Recommendation Report for Planning Permission for Works or Extension to a Dwelling

REF NO: P/100/20/HH

LOCATION: 35 Kings Drive
Pagham
PO21 4PZ

PROPOSAL: Single storey rear extension, first floor front extension and driveway with dropped kerb

Proposed Extension and Alterations
at 35 Kings Drive, Pagham
for Mr and Mrs S Gent
Drawing P01 October 2020 Scale 1:100 @ A3
Planning Drawing - Proposed Plans & Elevations

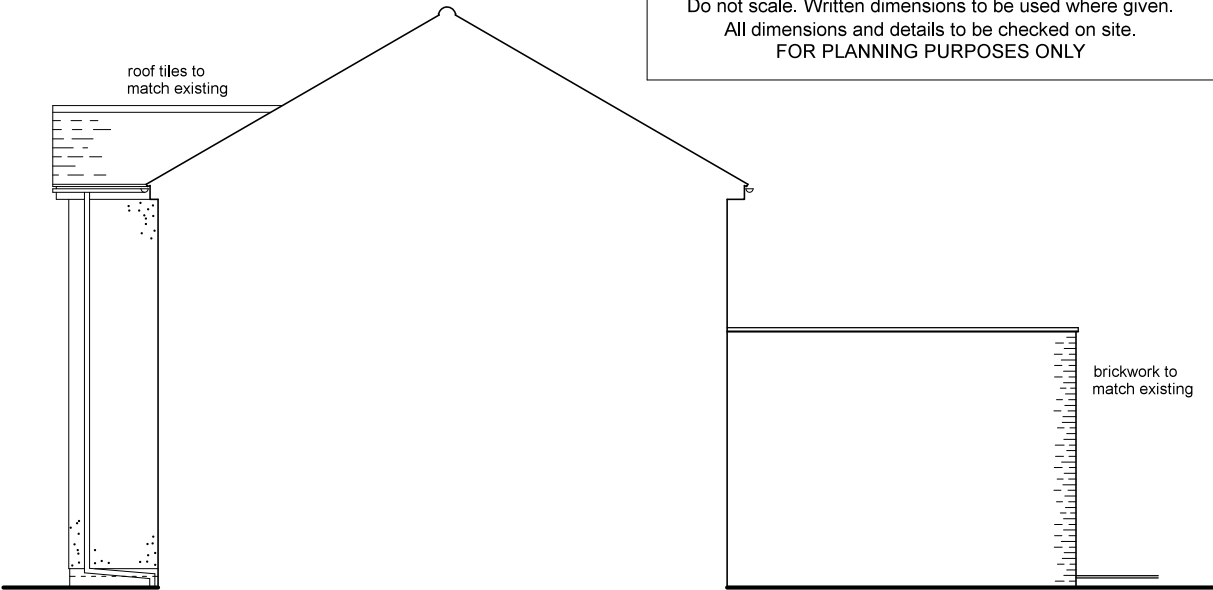
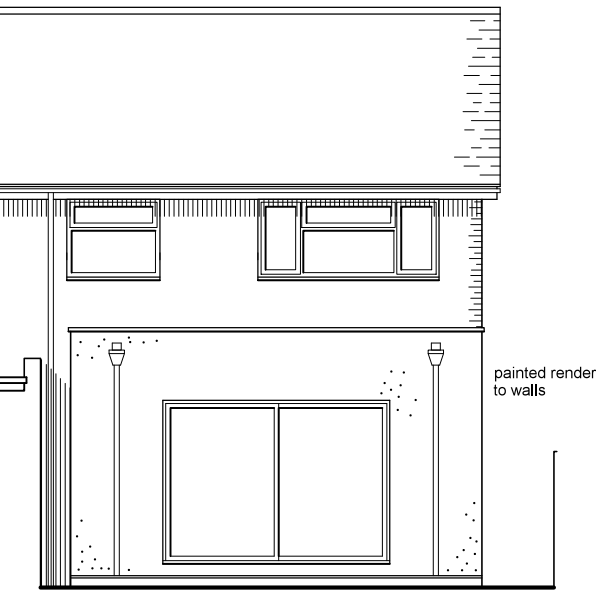
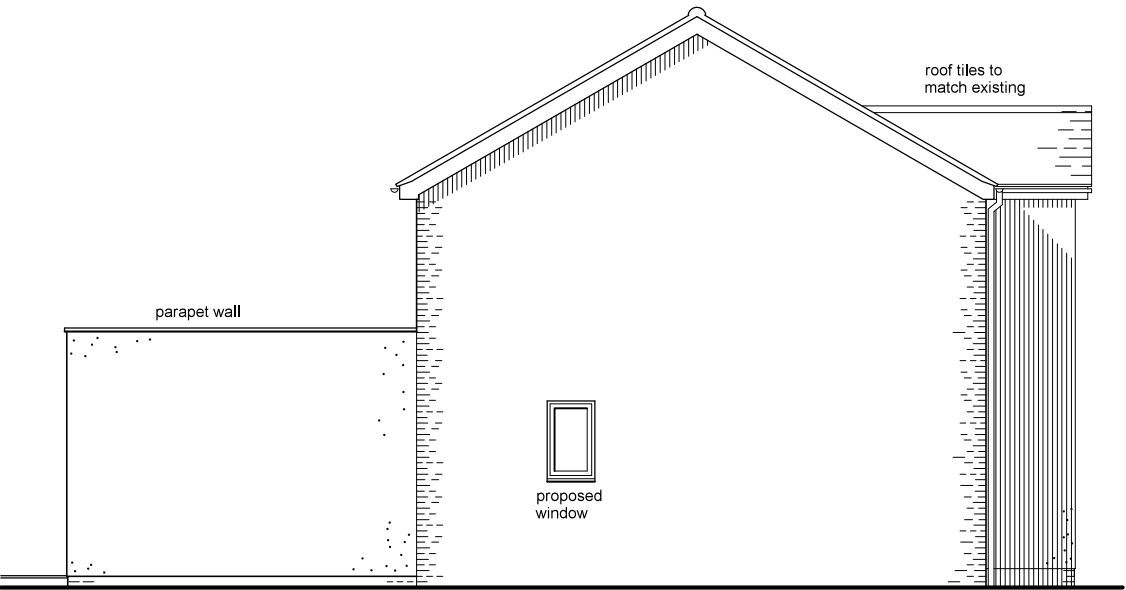
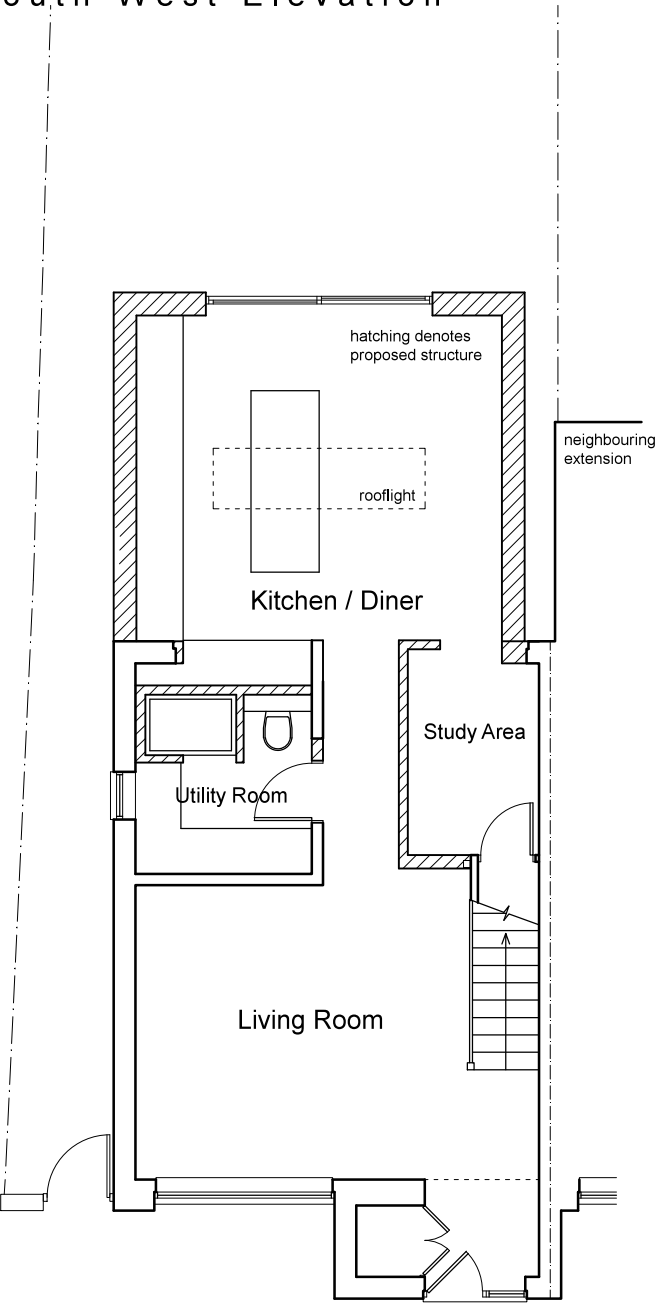
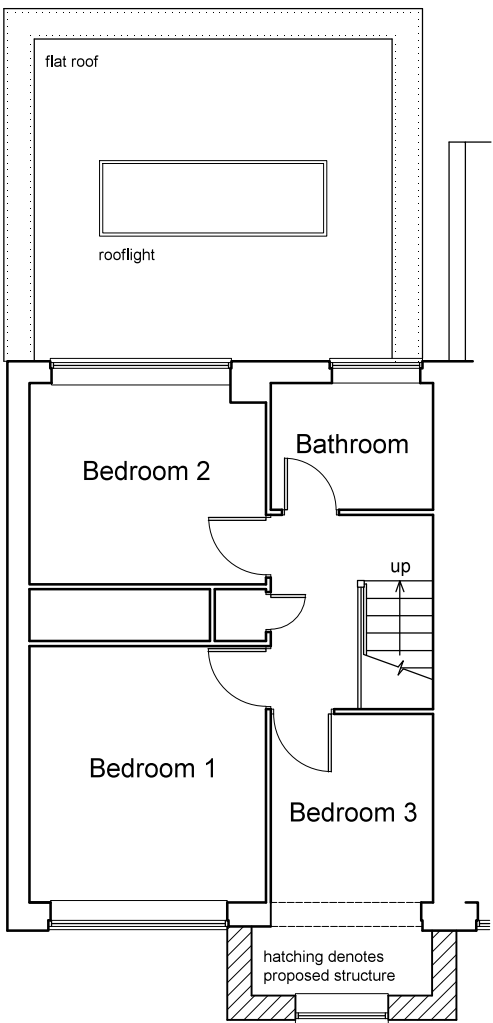
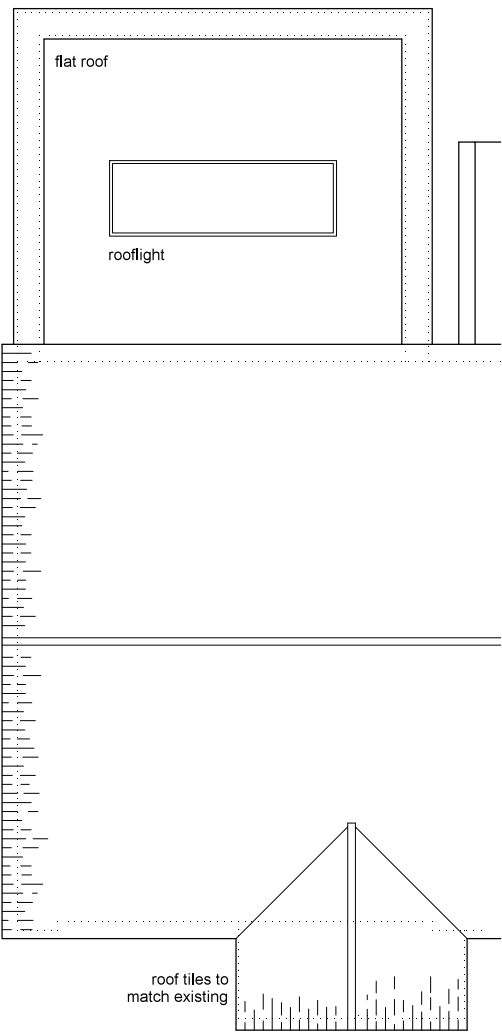
There is an existing porch and the first floor is proposed above. The depth is modest at 1.2m extending 3m along the front elevation. The first floor will have a pitched roof with eaves to meet with the host dwelling and appears well integrated with the use of the matching materials. The Arun District Council Design guide states front extensions should generally be no deeper than 1.5 metres which the proposal complies with.

The proposed rear extension will have a depth of 4.6m and will run along the full rear elevation retaining around 0.4m to the northern boundary. This will have flat roof with a height of 3.4m.

Whilst the addition will extend beyond the rear of the neighbouring property to the north by around 1.7m, the extension is not considered to result in adverse impacts, nor intersect a 45 degree angle from the rear openings. Due to the separation and location of the property to the south, it is not considered to give rise to impacts upon this elevation. An extension could be constructed up to this depth with prior approval with no objections from the neighbours and with no representation received, the development is considered acceptable.

The first floor extension as a result of the siting adjacent to the first window at No.37 to the north, it is considered to result in slight overshadowing and give rise to an overbearing impact due to it marginally intersecting a 45 degree angle. However as a result of the nearby example which is an identical property and had permission for the construction of a first floor in the same position as is proposed, it is not considered the impact can be considered significant in which a refusal is justified. The proposal is also smaller in depth than compared to the approved.

Proposed Site Plan

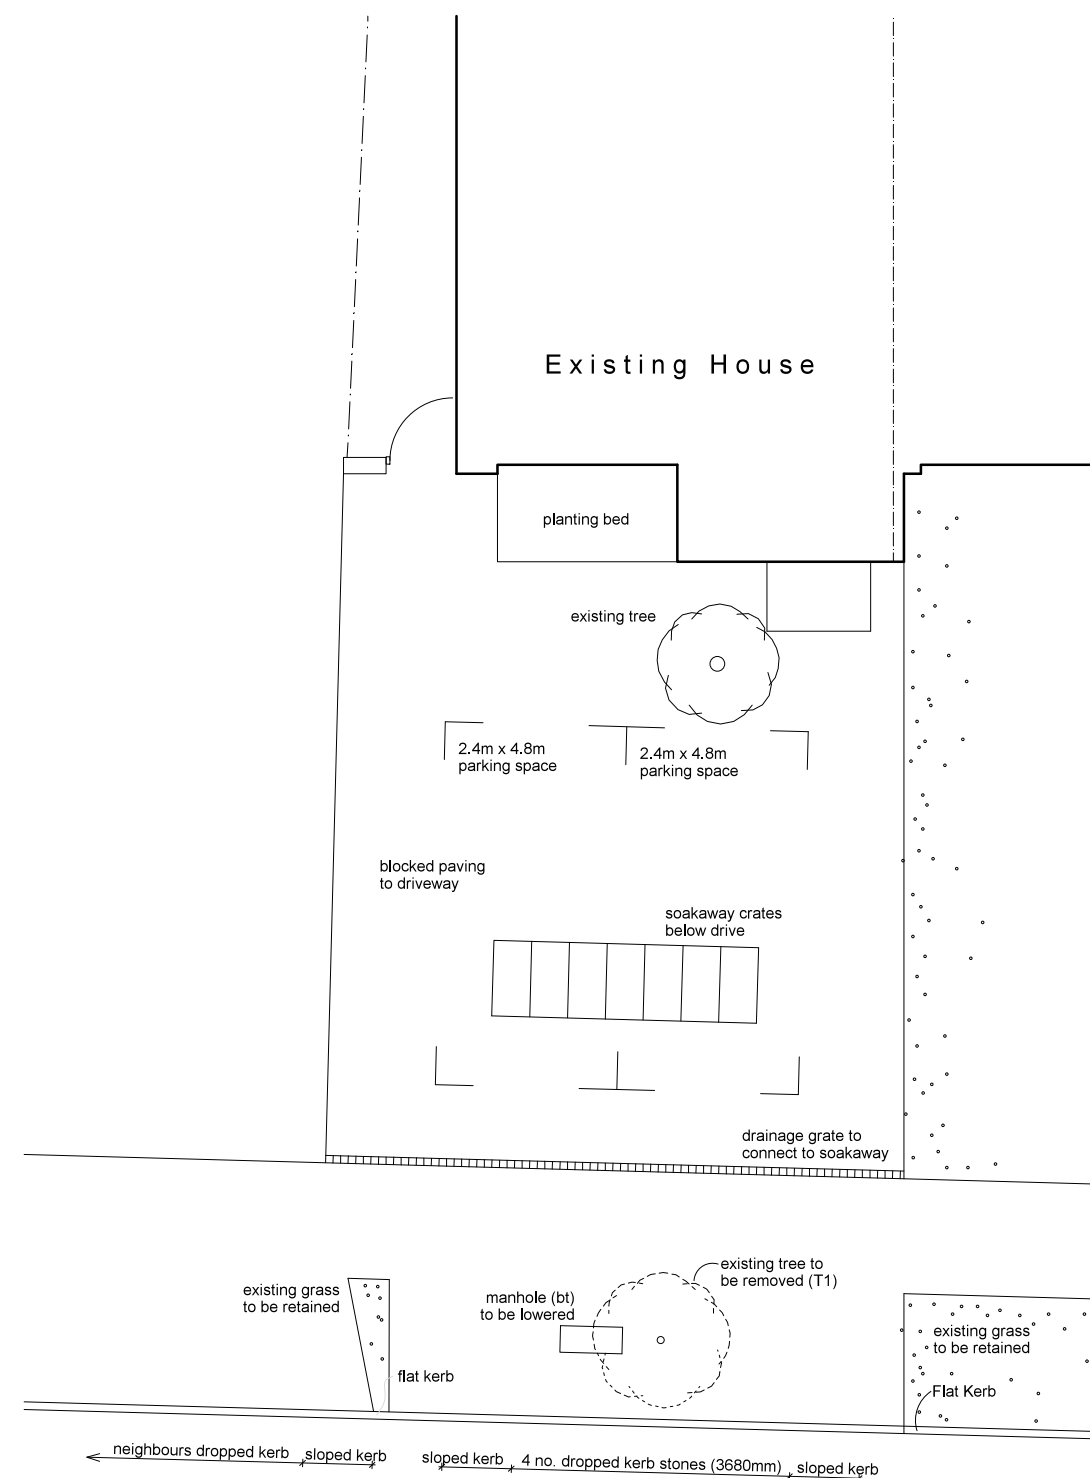
The proposal also seeks a dropped kerb and hardstanding for parking to the front of the property. This would enable parking for around 2 cars. There are others examples with a similar set up at nearby properties within the street and it is not considered to result in adverse impacts upon the area or neighbouring amenity.

- 3 The use of the access shall not commence until such time as the vehicular access serving the development has been constructed in accordance with the details shown on the approved site plan P02a.
